RESPONSE TO STATEMENTS SUBMITTED BY HIGHWAYS ENGLAND WITHIN RESPECTIVE WRITTEN REPRESENTATIONS TO DEADLINE 2

M and R Hosier for Boreland and Westfield farms – Ref: 20020373

Highways England Response to Examining Authorities written questions 8.10.11 Flood risk, groundwater protection, geology and land contamination (Fg1) Deadline 2 [1]

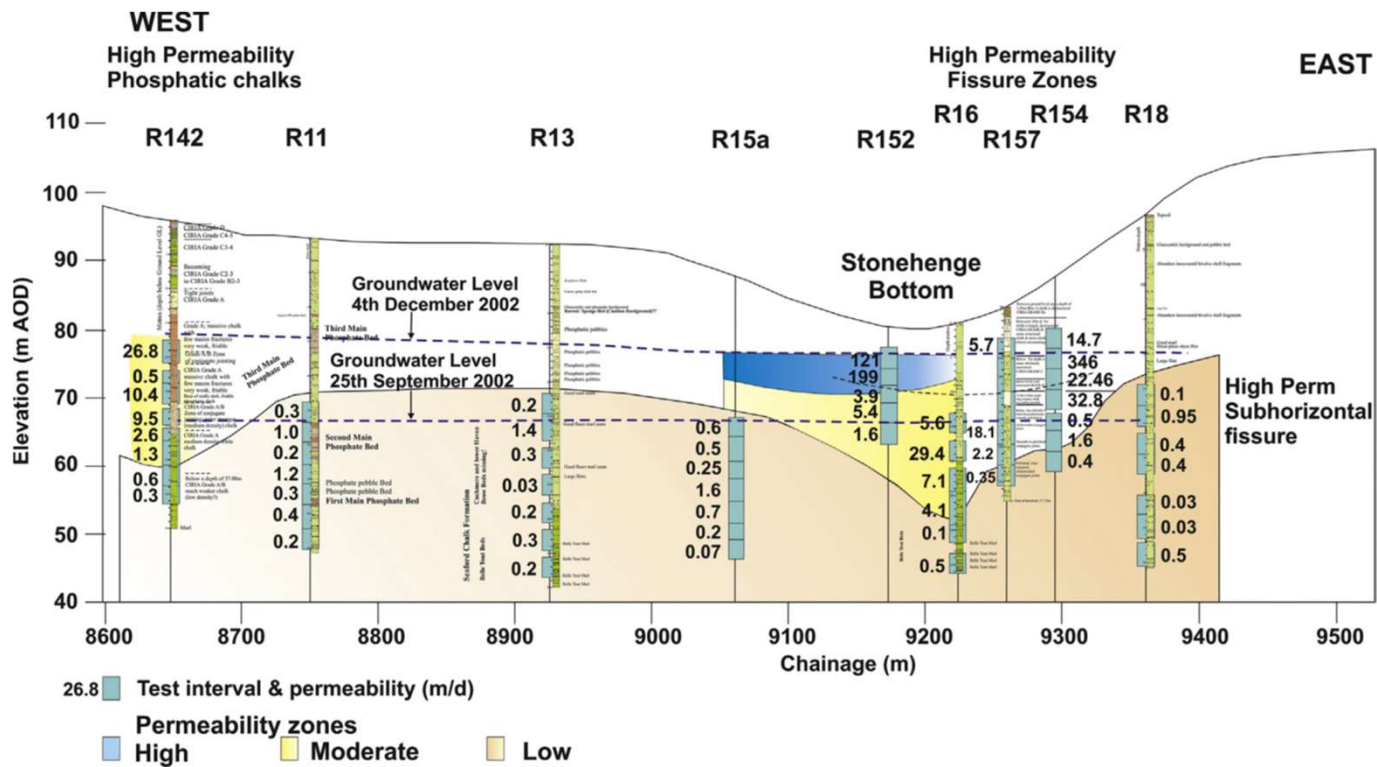
Mortimore et al Proc. Geol Assoc 2017 Figure 26 notes presence of many high permeability sub-horizontal fissures (dipping to the south) in the location of Stonehenge Bottom. As the tunnel is below the water table in this location and the exact location of the fissures will never be known unless the whole of the area is surveyed by core samples every few meters, it is not possible to assess the full damming effects that a tunnel will cause. Claims that the water will flow round cannot be accurately known until the tunnel is in place. There is a massive potential for the tunnel to alter groundwater flows far beyond the survey area.
